**KIRKLEES METROPOLITAN COUNCIL
INVESTMENT & REGENERATION SERVICE**

**DELEGATED DECISION TO DETERMINE APPLICATIONS FOR
CONSENT, AGREEMENT OR APPROVAL REQUIRED BY CONDITION**

Reference No:	2025/44/93178/W
Site Address:	Land at, Penistone Road, Fenay Bridge, Huddersfield, HD8 0AW
Description:	Discharge of details reserved by conditions 6 (sustainability), 22 (BEMP), 29 (Travel Plan), 32 (Lighting), 35 (cycle storage) on previous permission 2022/93154 for erection of 68 dwellings with associated access, parking, open space, landscaping and infrastructure works (including installation of surface water attenuation tank)
Recommending Officer:	Katie Chew

Application: 2025/93178

DRAWING TITLE:	Typical Shed Arrangement
----------------	--------------------------

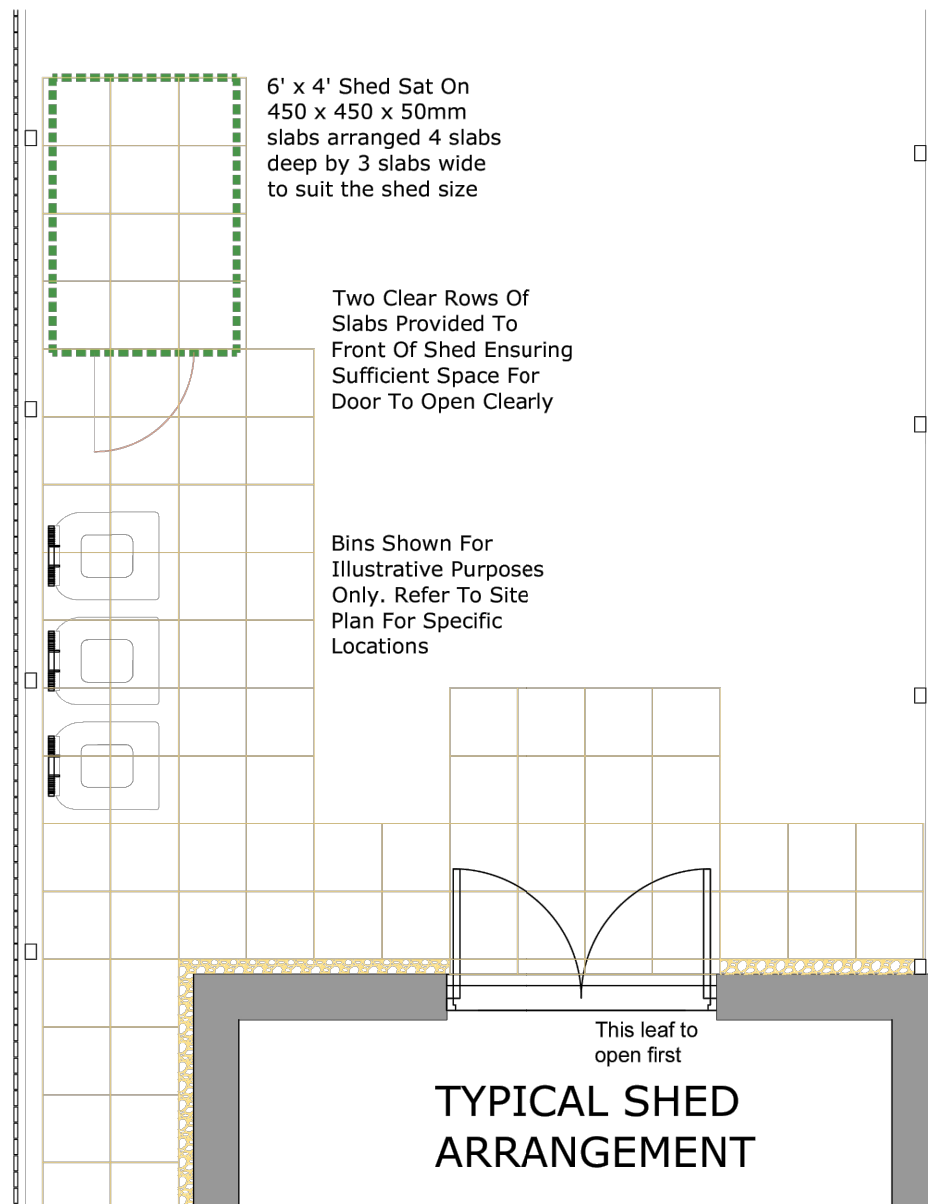
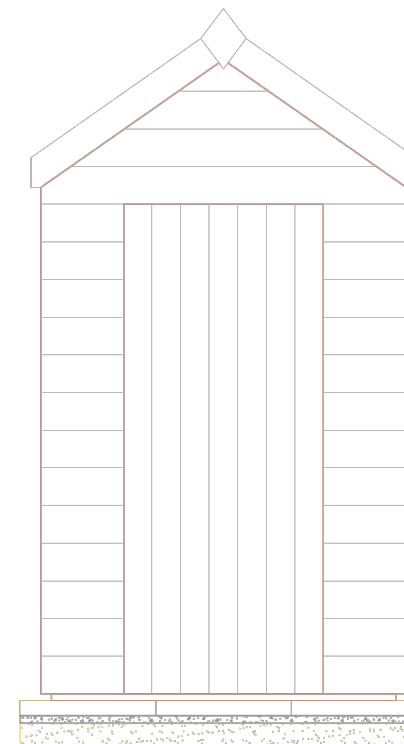
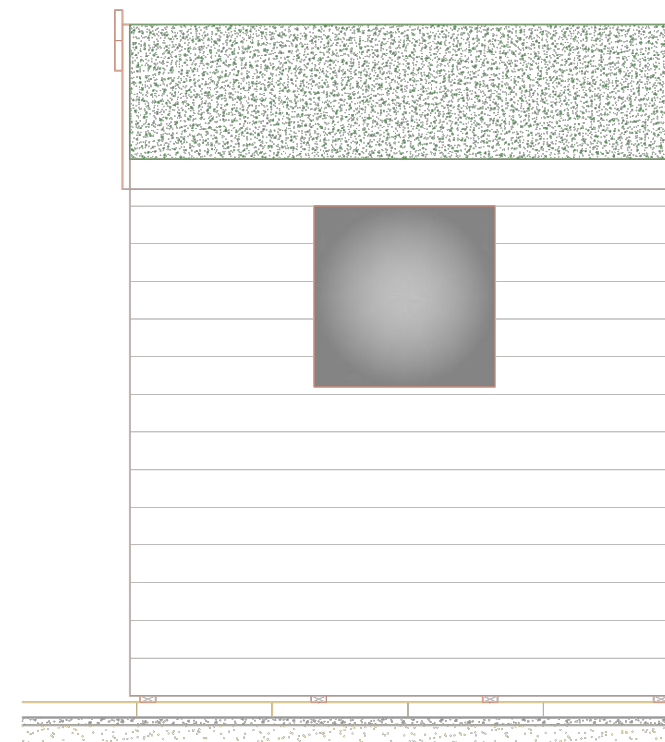
Could the applicant please clarify what security measures are proposed.

The shed/ cycle store should be securely fixed to the substrate foundation. Windows should be avoided. Hinges should be coachbolted through for extra security. Cycle store should contain a rated storage device inside, such as a ground anchor, stand or a rack. Minimum security standards are as per below:

Sold Secure SS104 Bronze, STS 225 Issue 2 Burglar Resistance BR1(S), STS 205 Issue 8 Burglar Resistance BR1, STS 225 Issue 2 Burglar Resistance BR1(S), LPS 1175 Issue 8 Security Rating A1, STS 501 Security Rating TR1 or STS 503 Security Rating TR1.

With regard to the cycle storage, the confirmation that the sheds are securely fixed to their foundations and include a Sheffield stand fixed into the base should satisfy reasonable security expectations for cycle provision.

With regard to cycle storage- now that further clarification has been provided, the condition can be discharged as it mentions a secure and covered cycle storage.

Figure 3. External dwelling lux plot (central)

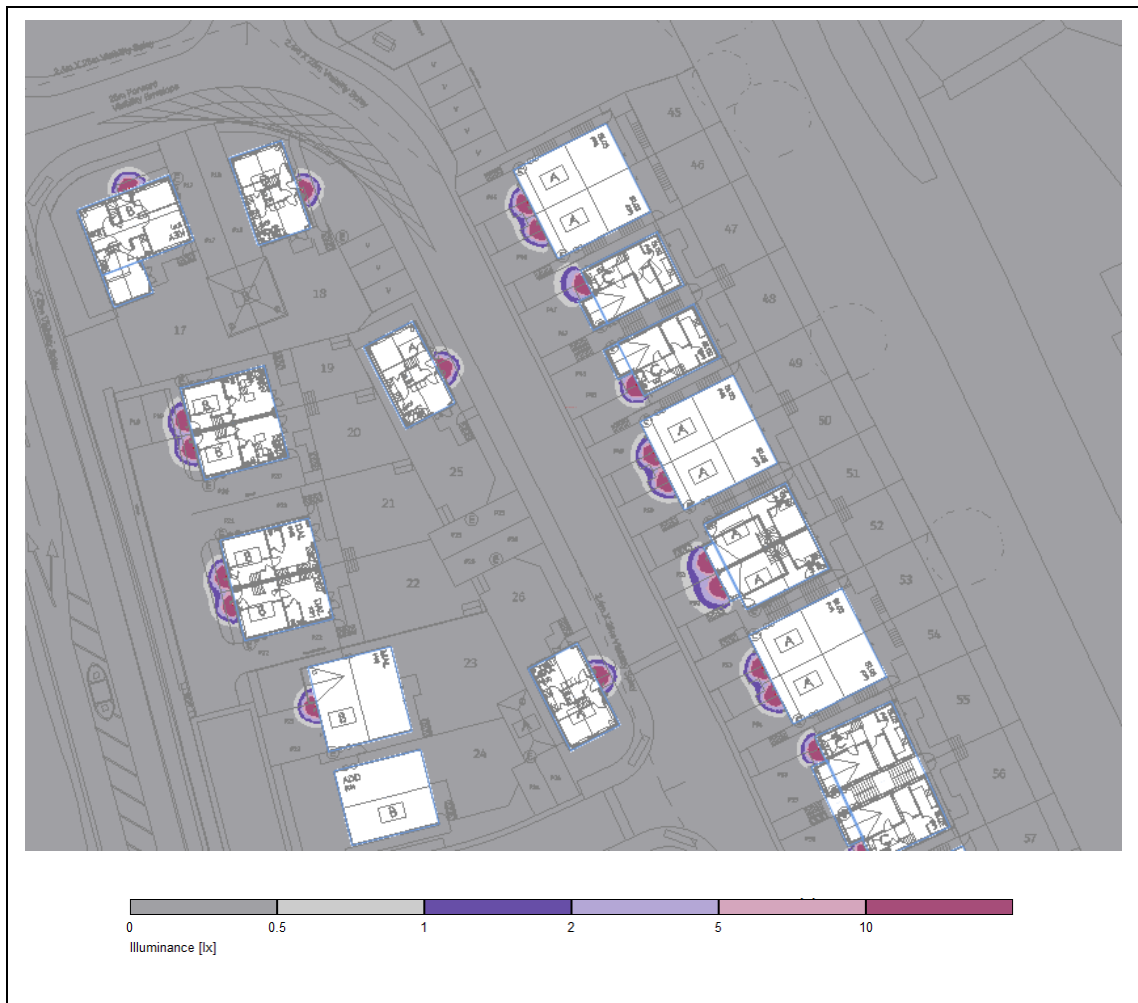
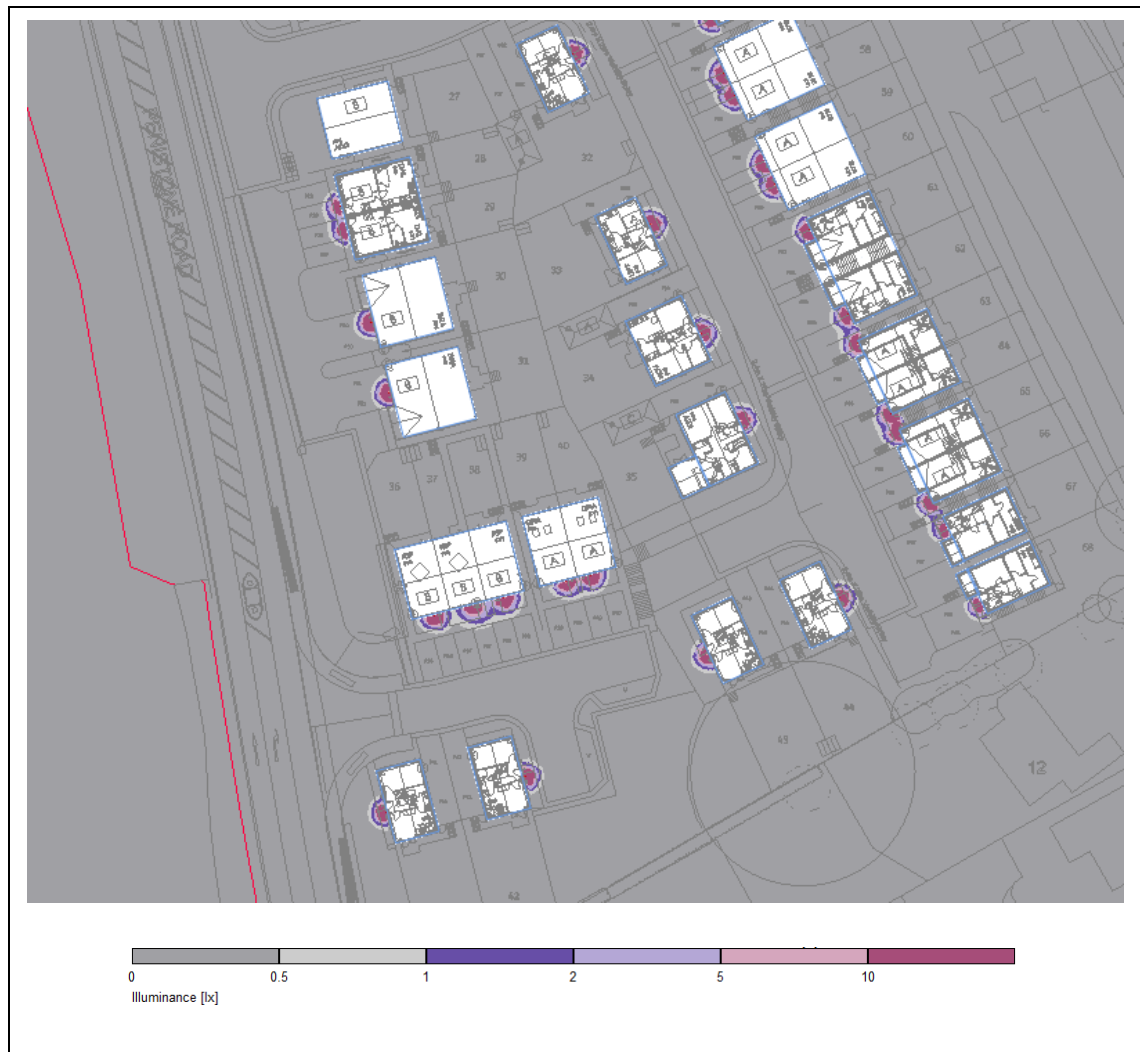
PIR-enabled external dwelling lights are not supported from a crime reduction perspective due to operational inconsistency, proneness to criminal damage, enhancing the fear of crime due to false activations and contributing to neighbour tensions due to the lights flashing on and off.

I note the remarks suggesting that the proposed luminaires would have a manual override function however, from open source research, I believe they will automatically revert to the PIR mode daily, making it somewhat cumbersome for homeowners who wish to regularly use the override facility. Could they be replaced with dusk till dawn sensor luminaires instead?

Additionally, all external doorsets- not just the front one- should be illuminated by dusk till dawn enabled lighting so the doorways are observable and intruders easier to spot in the hours of darkness. This includes patio doors.

The condition mentions external lighting in the context of amenity, biodiversity and security, in the interests of ecological and crime mitigation. Rear doorsets are a vulnerable entry point for acquisitive offenders which is why they should be illuminated- to deter criminals, make them more visible, avoid creating concealment opportunities and provide enhanced surveillance opportunities in the hours of darkness.

Looking at dwelling burglaries in Fenay Bridge from 14/01/2022 (due to the initial application for this development dating back to 2022) until 14/01/2026 on Police crime and incident database- out of 24 offences: 10 dwellings were entered through rear doors (predominantly patios), 6 by attacking a window, 6 by attempting the front door (usually opportunistic with suspects trying the door handle before walking away), 2 via garage doors.

As it stands, rear doorsets- particularly patios- are the most popular method of entry for residential burglaries within the area local to this development. My view- that these doorsets should be illuminated with dusk till dawn lighting- remains unchanged.

In my experience, unless a planning condition or informative explicitly requires compliance with Secure by Design, applicants are not obligated to meet that standard in full, as it is a police-approved initiative rather than a mandatory requirement.

From a regulatory perspective, the baseline requirement for new dwellings is Part Q of the Building Regulations, which you have confirmed is being met through the specification of doors and windows to the appropriate British Standards and security ratings. On that basis, the Crime Prevention Officer's comments do appear to go beyond the mandatory requirements.

Similarly, the approach to external lighting aligns with Part L (Conservation of Fuel and Power), which prioritises energy efficiency and low-carbon outcomes. This is a statutory requirement, and the proposed lighting strategy appears compliant while still providing a reasonable level of security. The provision of lockable rear gates also represents a proportionate and recognised crime prevention measure.

Whilst the above assessment and comments from DOCO has been considered, given that the applicant has been made aware of KC DOCO's concerns and this advice may be passed on to future occupiers of the properties, who if they wish to do so, could seek to install additional lighting to the rear of their property in the interests of security. In so far as Condition 32, Officers consider sufficient external lighting has been provided to meet with this condition. Therefore, it is recommended that Condition 32 be discharged.
